**Re: Amendment Letter – Phase Two Environmental Site Assessment**

47 Beechwood Avenue, 5 Springfield Road, and 12 Douglas Avenue, Ottawa, Ontario  
Pinchin File: 321299.001

As requested, Pinchin Ltd. (Pinchin) is pleased to offer the following comments and amendments with respect to the following document prepared by the City of Ottawa: *Phase 2 Pre-Consultation: Meeting Feedback for the Proposed Zoning By-Law Amendment Application and Site Plan Control Application – 47 Beechwood Ave, 12 Douglas Ave, and 5 Springfield Rd* (File No. PC2023-0238) for the above-noted Site.

INFERRED
GROUNDWATER
FLOW DIRECTION

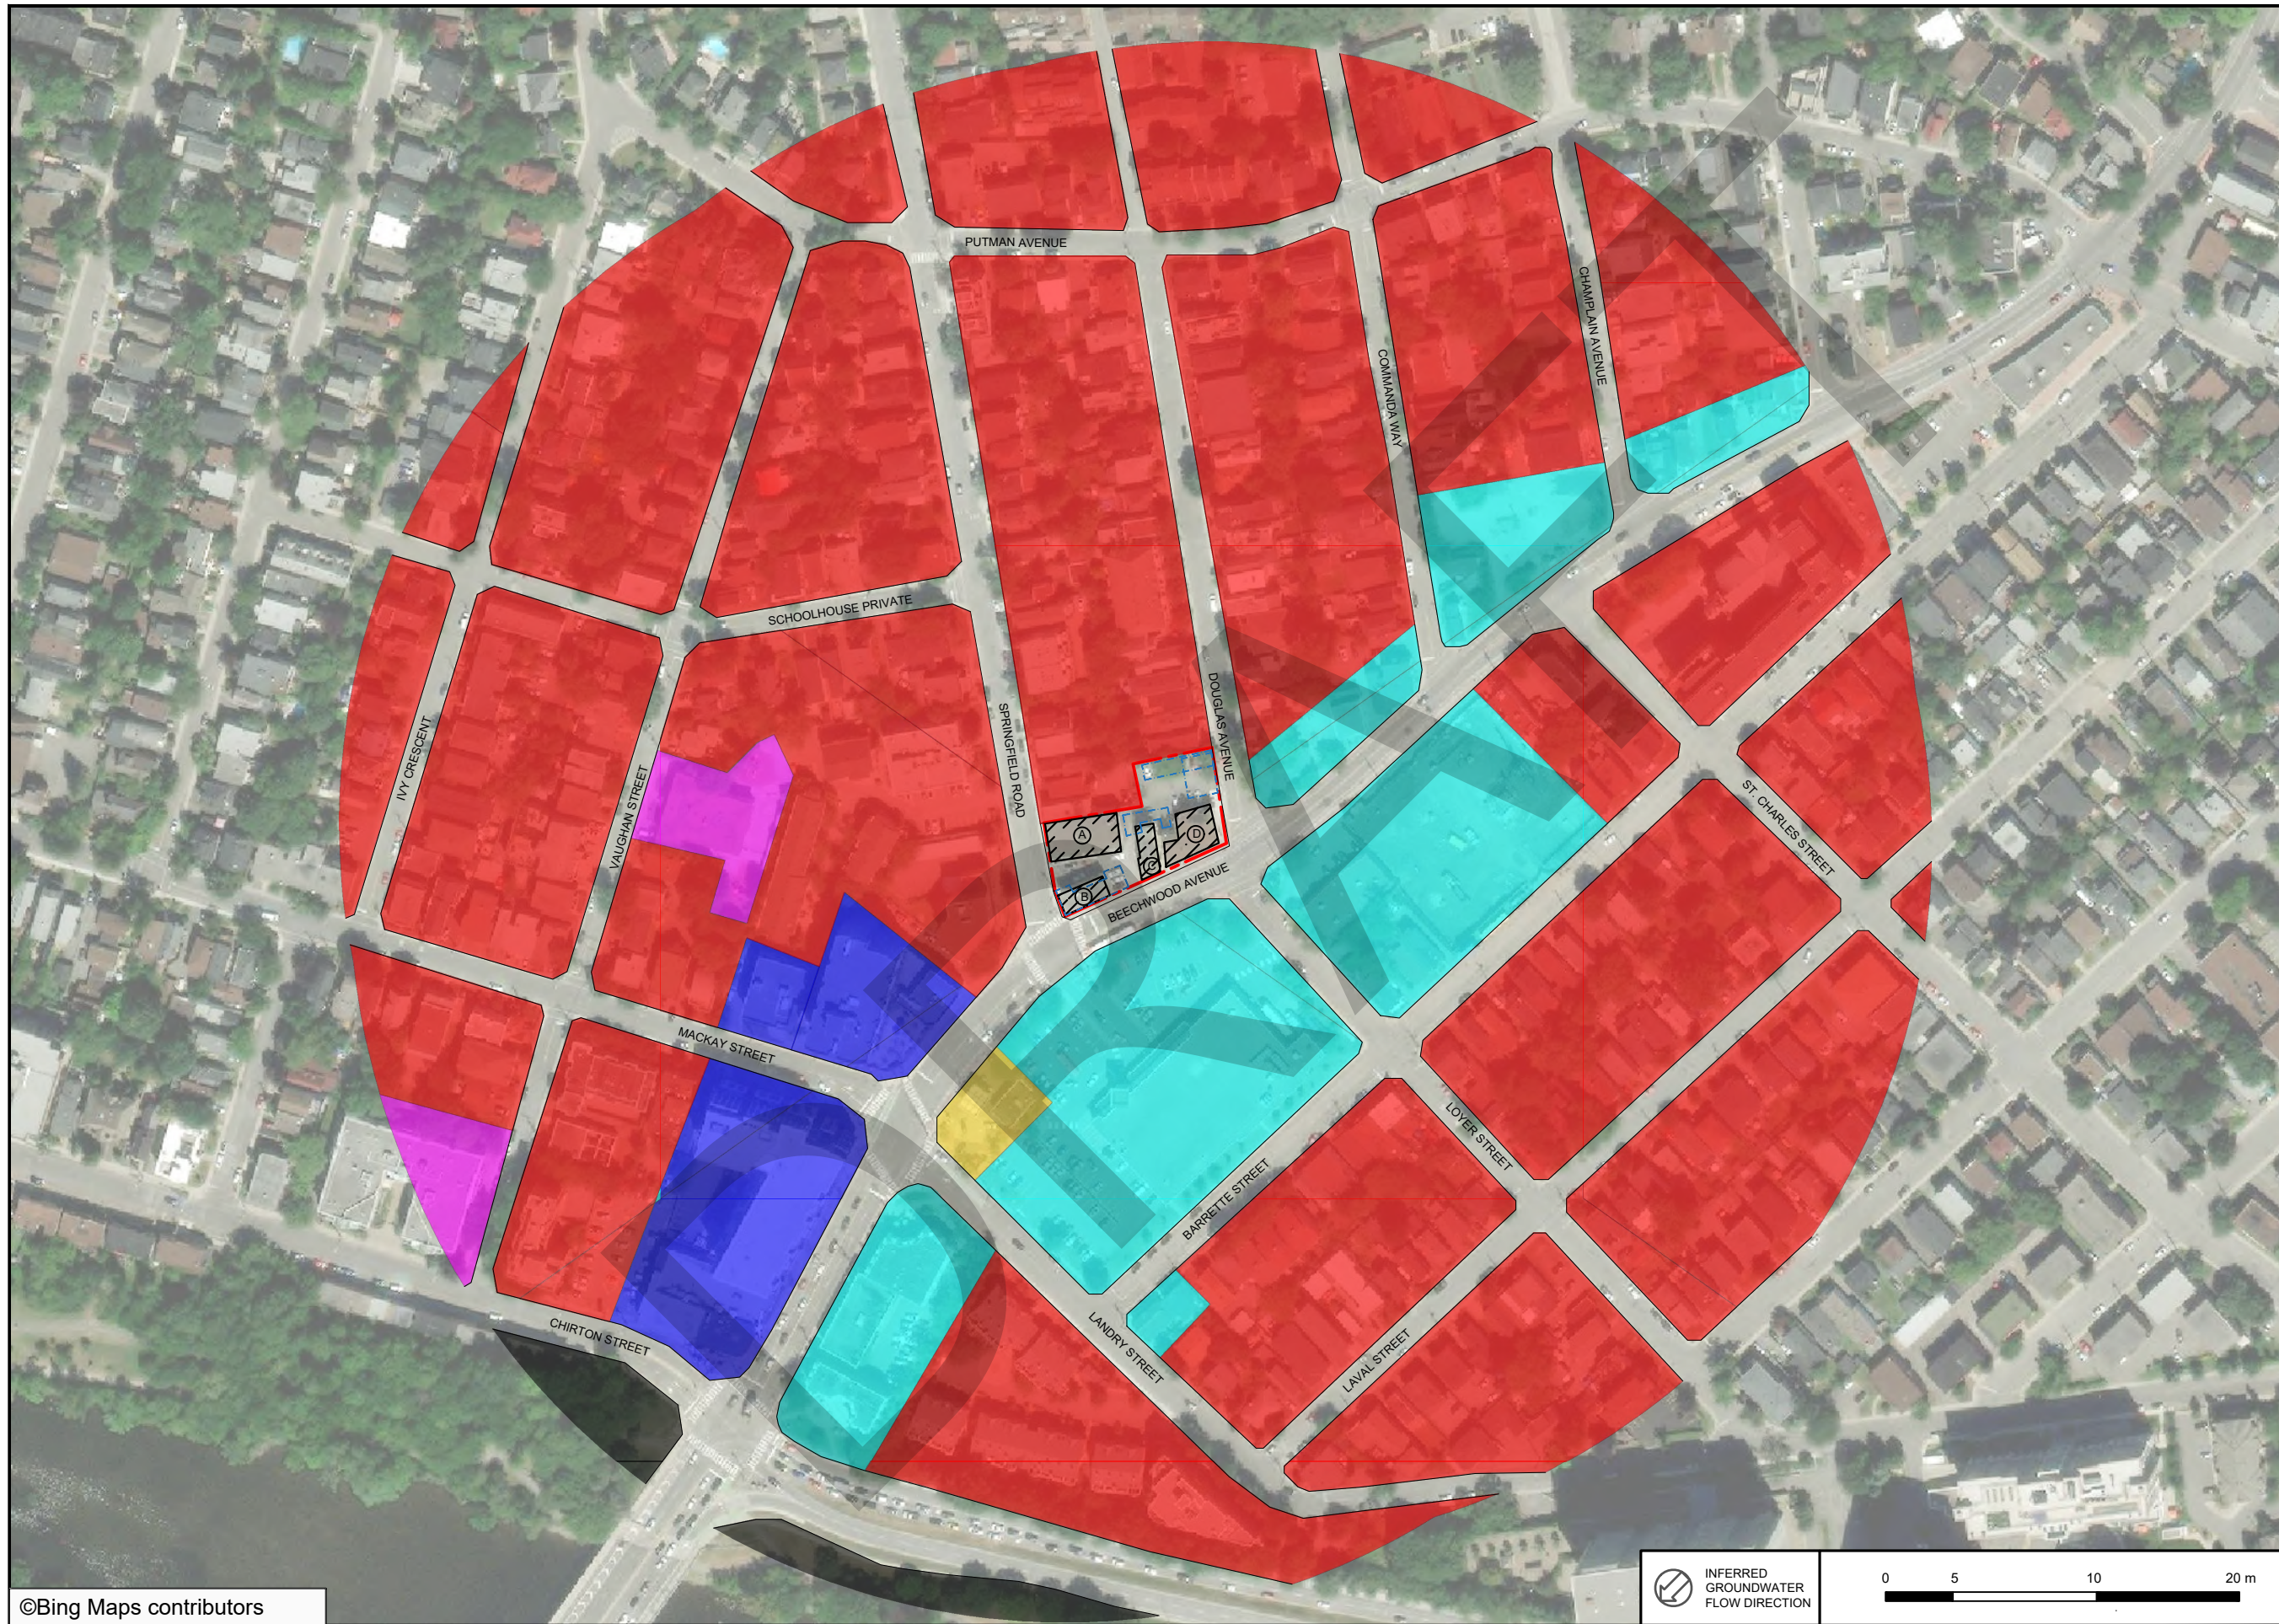
**Item 4.2.** The Phase One ESA reported the historical presence of two dry cleaners within the building located at the southwest corner of the property, which required further investigation. Three monitoring wells were installed onsite to address the potential impacts by the former dry cleaners. According to the Phase Two ESA, the local groundwater water flow direction is reported towards west. Therefore, based on the site plans, neither of the installed monitoring wells are located downgradient of the potentially contaminating activity (dry cleaners) and thus may be incapable of capturing a potential groundwater contamination. Further investigation and inclusion of an off-site contamination management agreement may be required.

With respect to Item 4.2, Pinchin recognizes that the groundwater flow from the July 26, 2023 groundwater monitoring event calculated that the local groundwater flow direction was towards the west, as reported in the Phase Two ESA report. However, the groundwater monitoring data from July 7, 2023 indicated that the groundwater flow direction was to the east/southeast, which could indicate that groundwater impacts from the former potential on-Site dry cleaners would have been captured by monitoring well MW4. The groundwater flow direction and contours from July 7, 2023 are shown in the attached Figure 1. Pinchin recognizes that groundwater flow direction is subject to seasonal and climatic variations, and can also be impacted by underground utilities, and as such, recommends continuing to monitor the groundwater elevations on-Site to further confirm the groundwater flow direction. In the interim, Pinchin has prepared a work plan and cost estimate to install a new groundwater monitoring well adjacent to the west property boundary to address the City of Ottawa's concern.
